Application No: K/55/20/PL
Site Address: 57 Coastal Road Kingston BN16 1SN
Description of works: Demolition & erection of 1 No. dwelling. This application is in CIL Zone 4 and is CIL Liable as new dwelling.

Thank you for your internet representation made on 21st December 2020 which has been recorded as an objection with the comments as follows:

For ST Charles Homes LTD	
Drawing Proposed Plans&Elevations	
Project La Casa, 57 Coastal Road, West Kingston East Preston BN16 1SN	
Scale	1:100
Date	19.11.2020
Made by Arch. Grygorieva A.A.

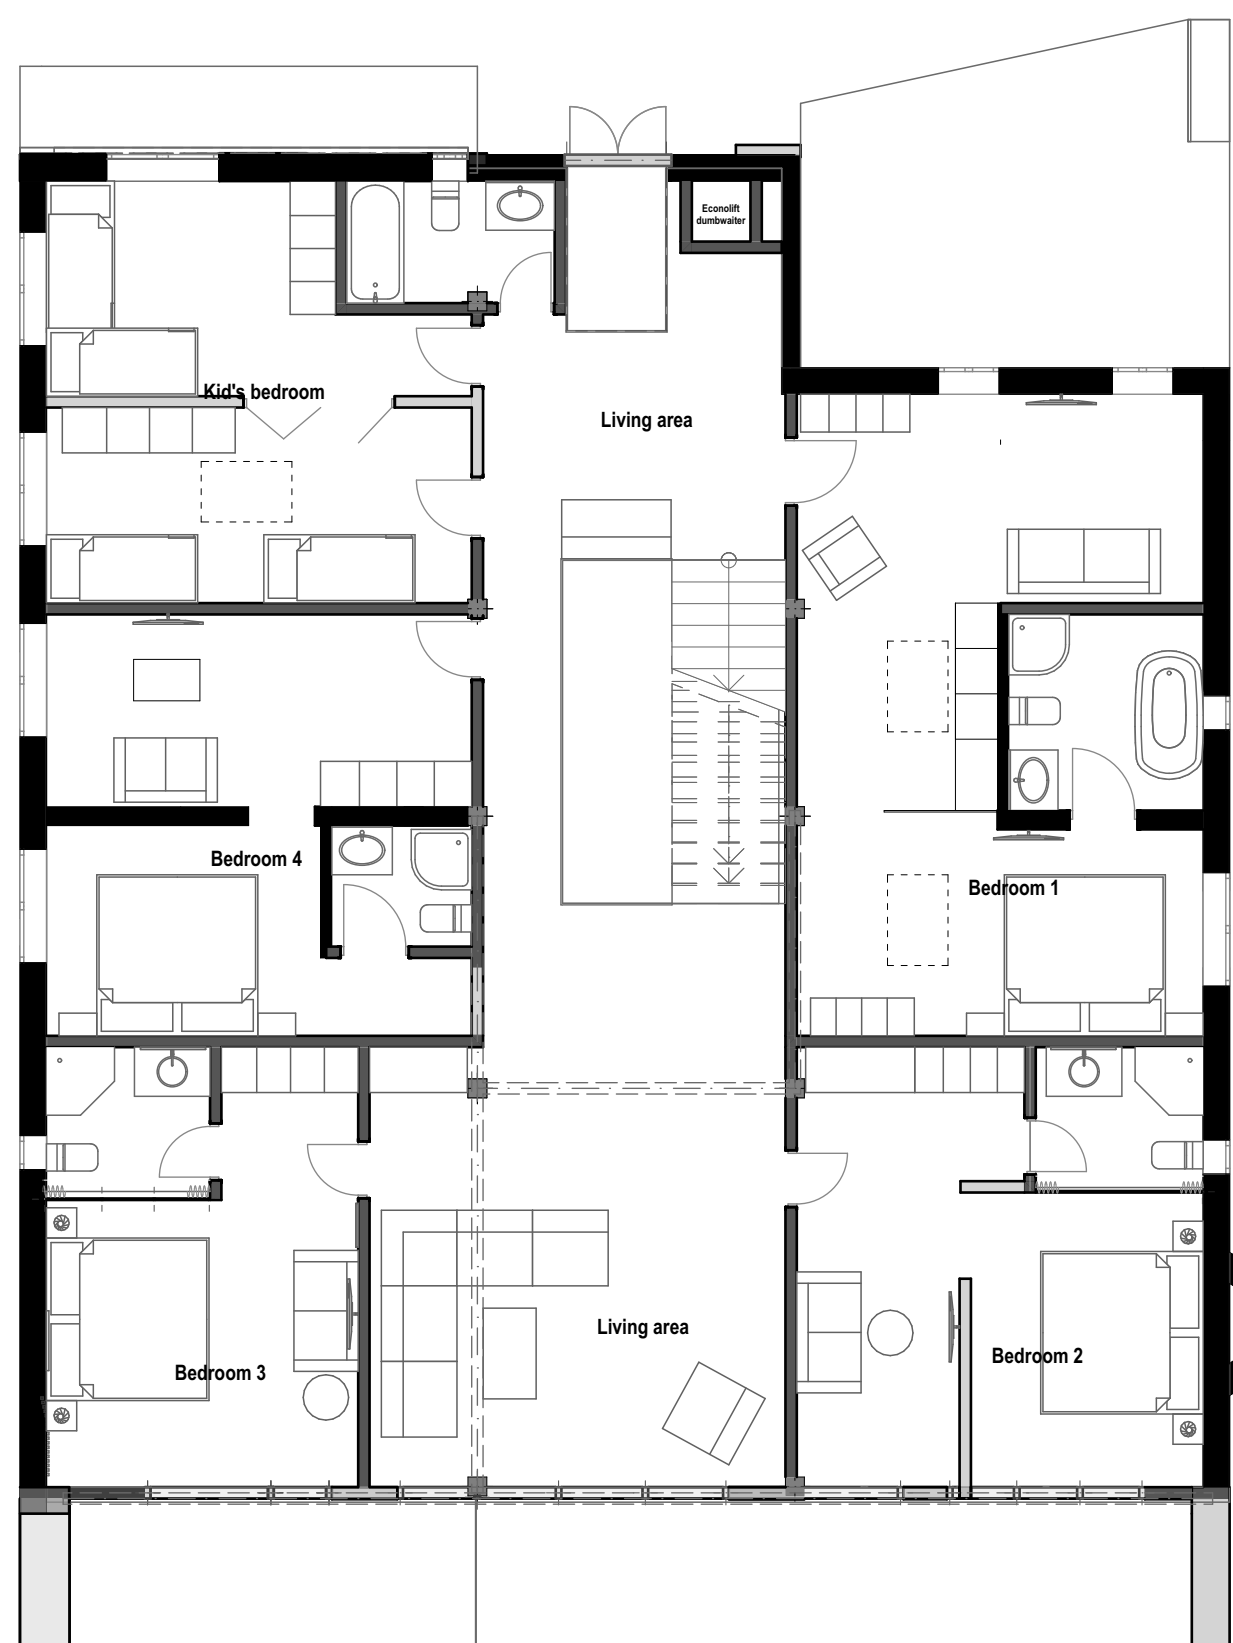
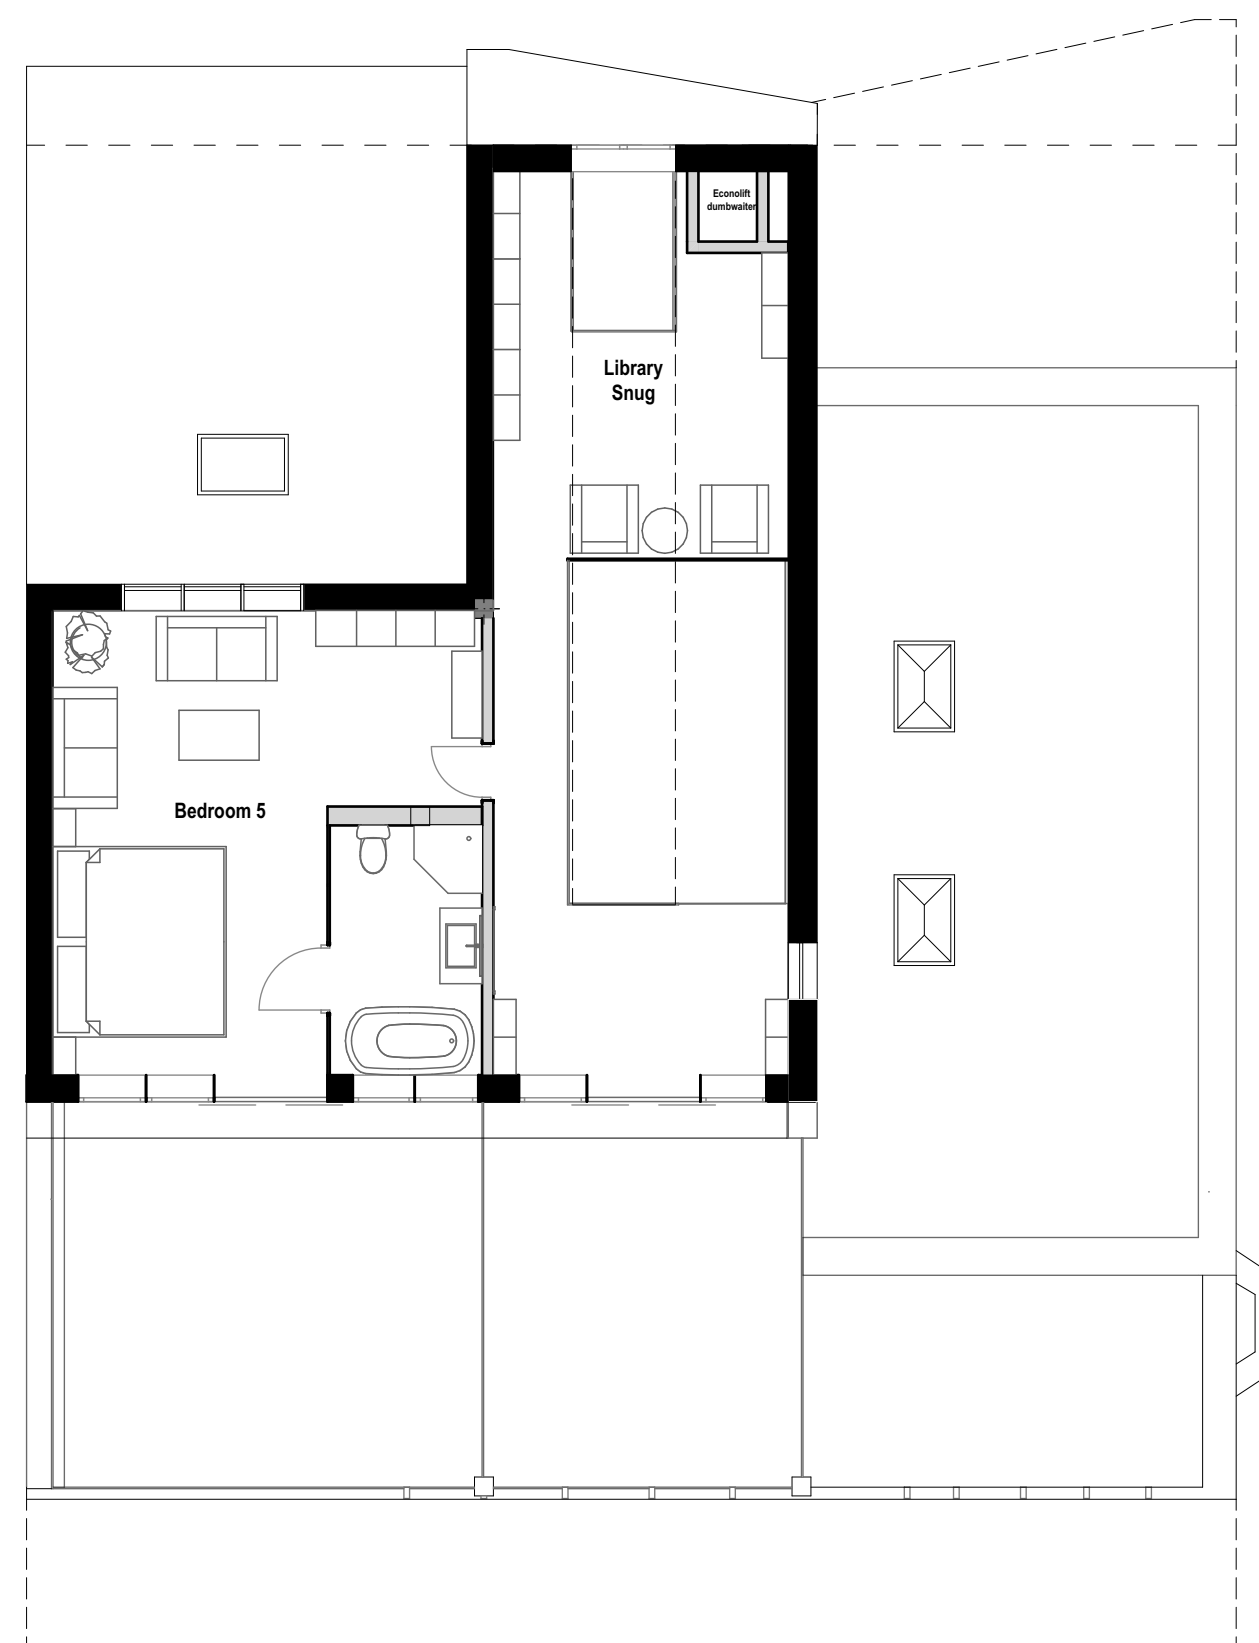
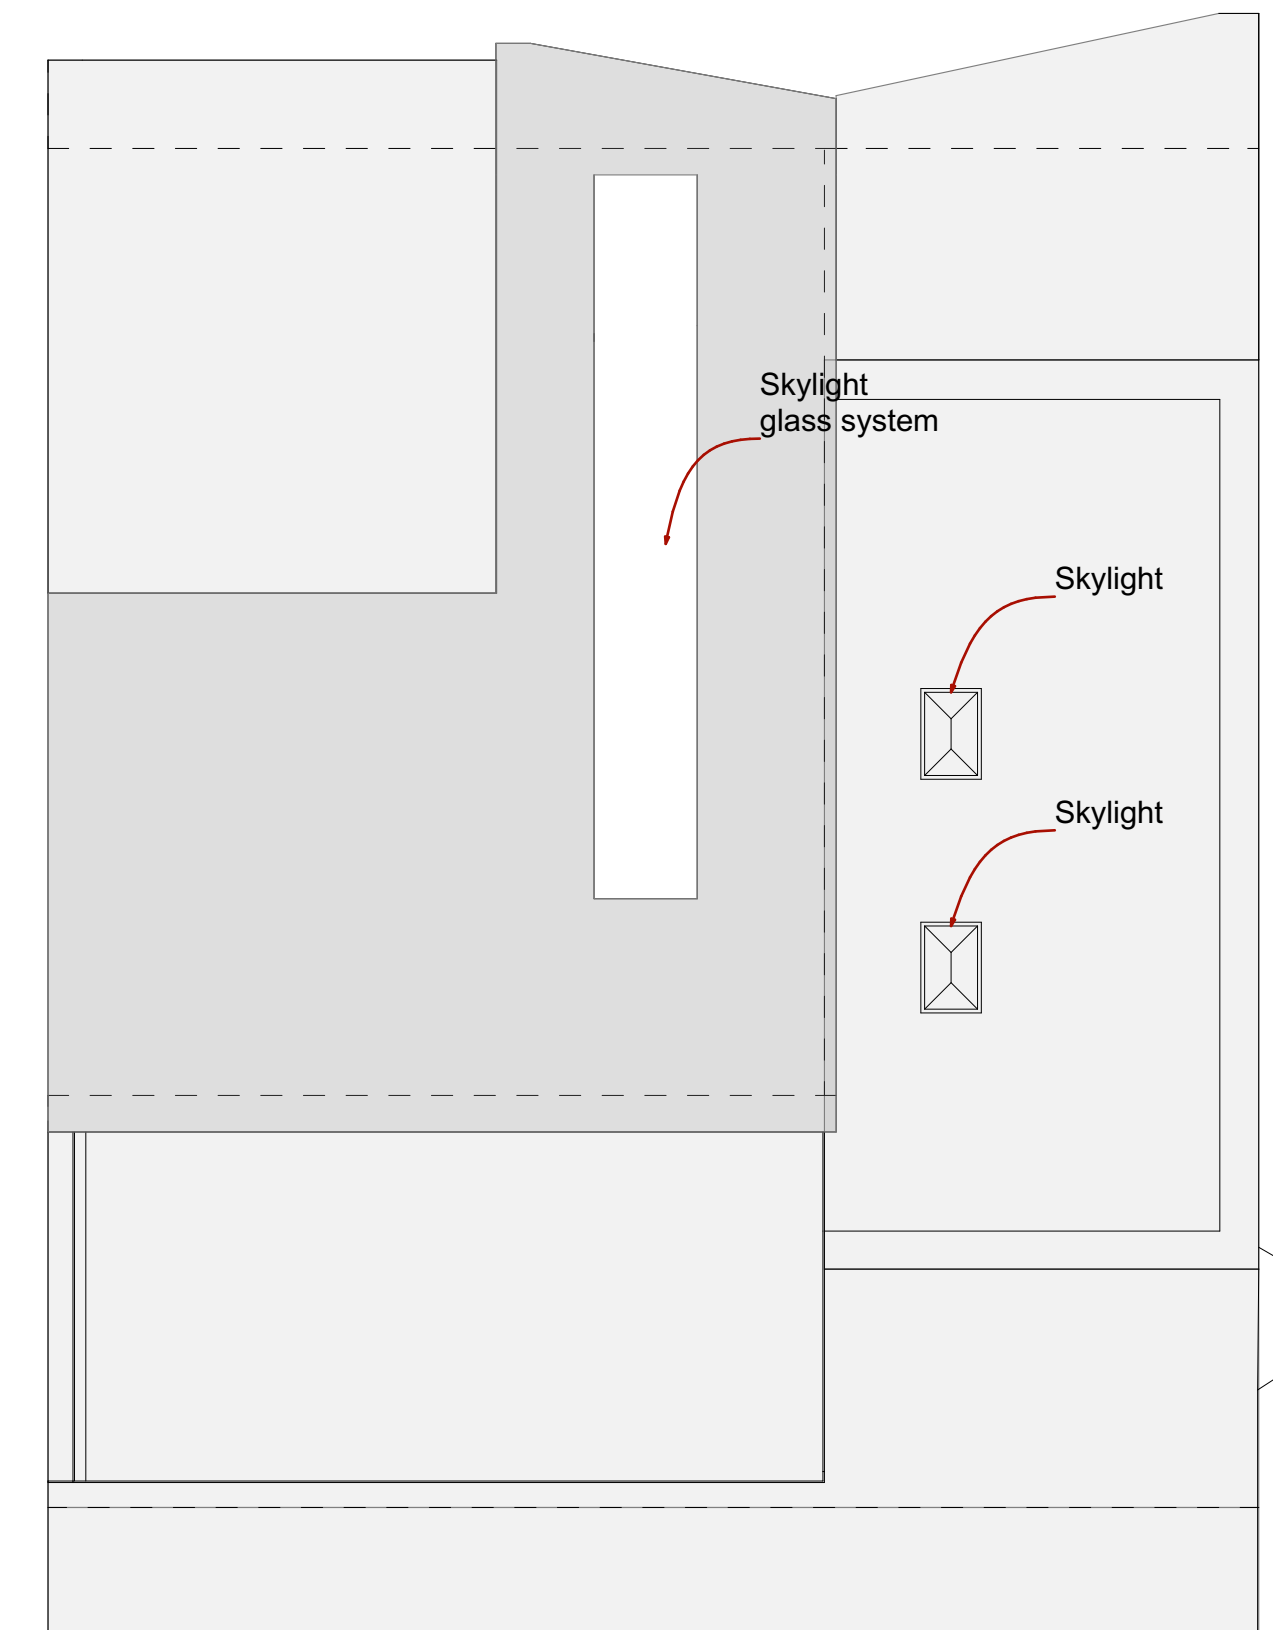
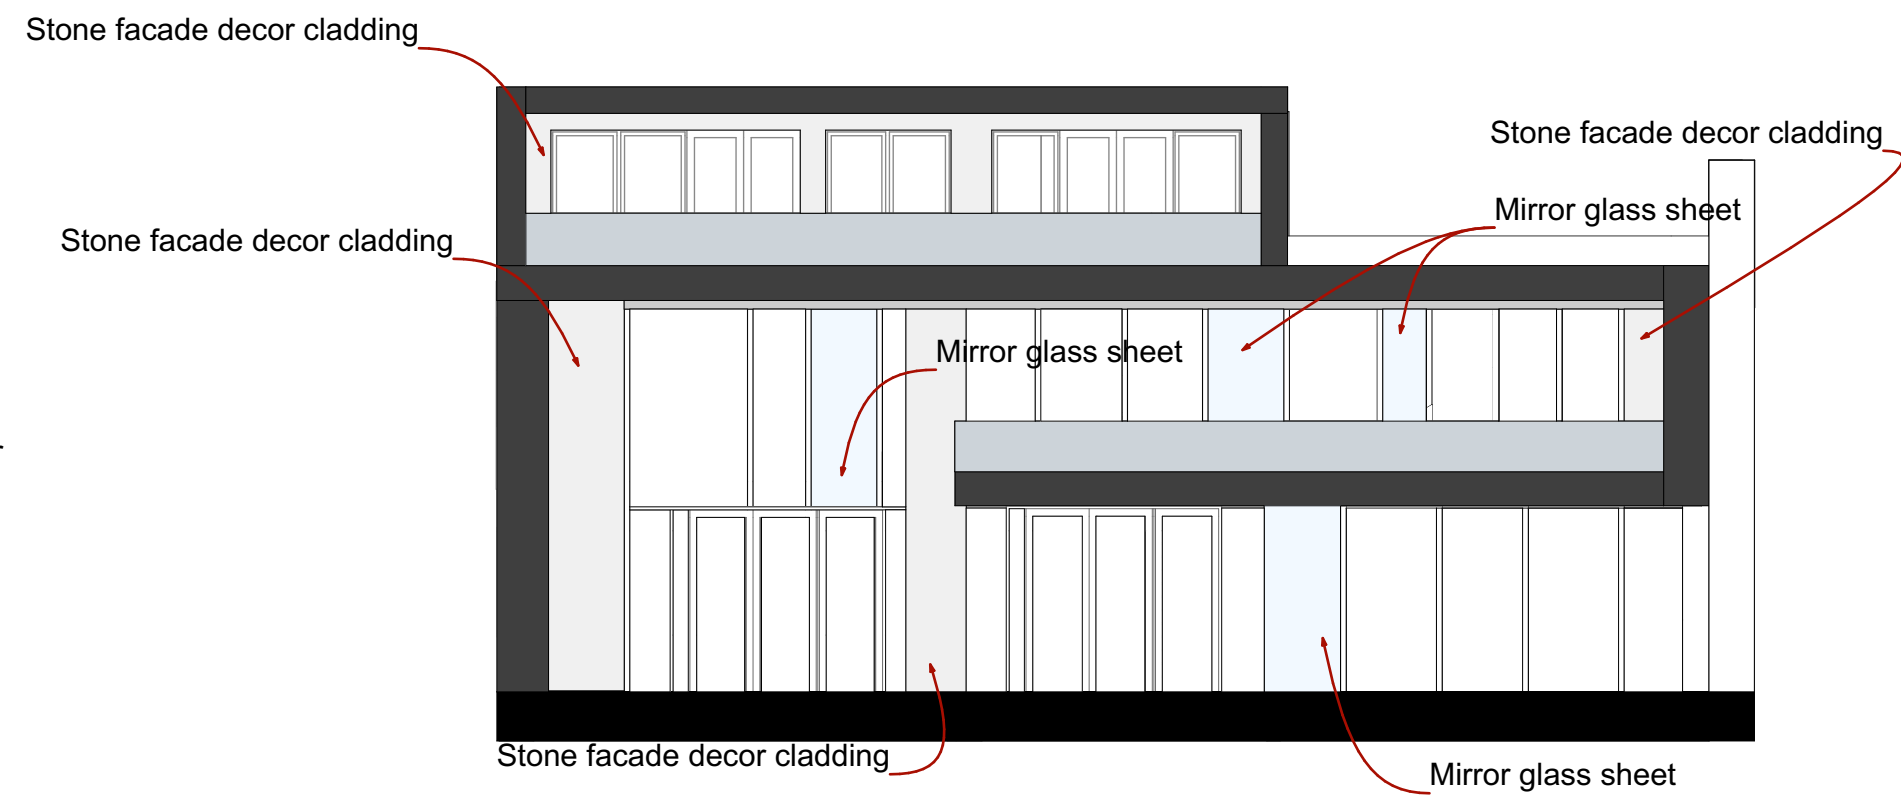
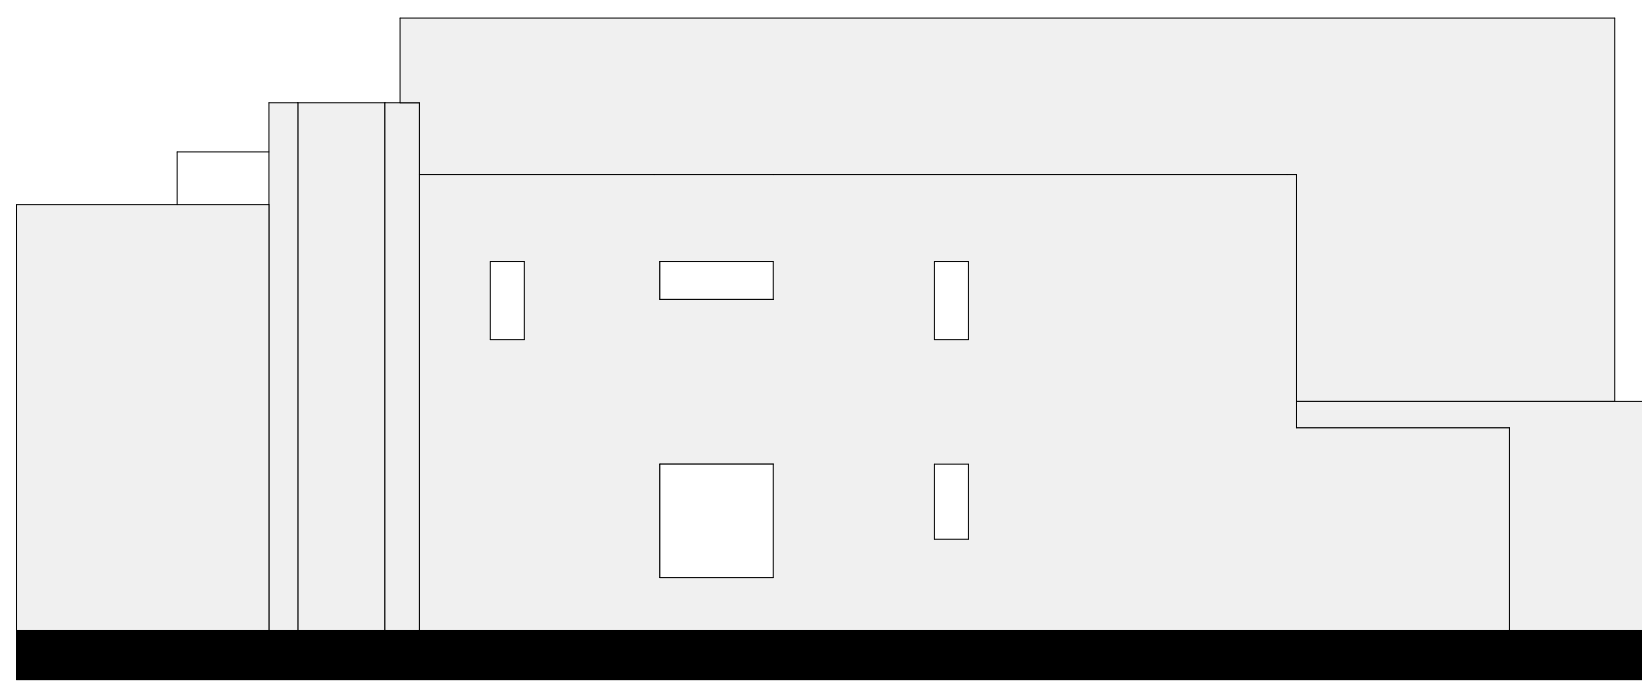
As with the previous application in 2018 we object very strongly to the size and scale of the whole planned proposal as it will affect all adjoining properties and the whole road scene. The footprint is enormous and more than twice the size of our property. As well as this the applicant wishes to extend the southern building line beyond the previous application. This is very detrimental to ourselves but also sets a bad precedent as it is out of keeping with all other properties.

The proposal will affect our privacy light and is totally overbearing. This is a particularly unneighbourly application due to it's scale but also because of the property size it will most likely be used commercially as a large scale holiday letting operation.
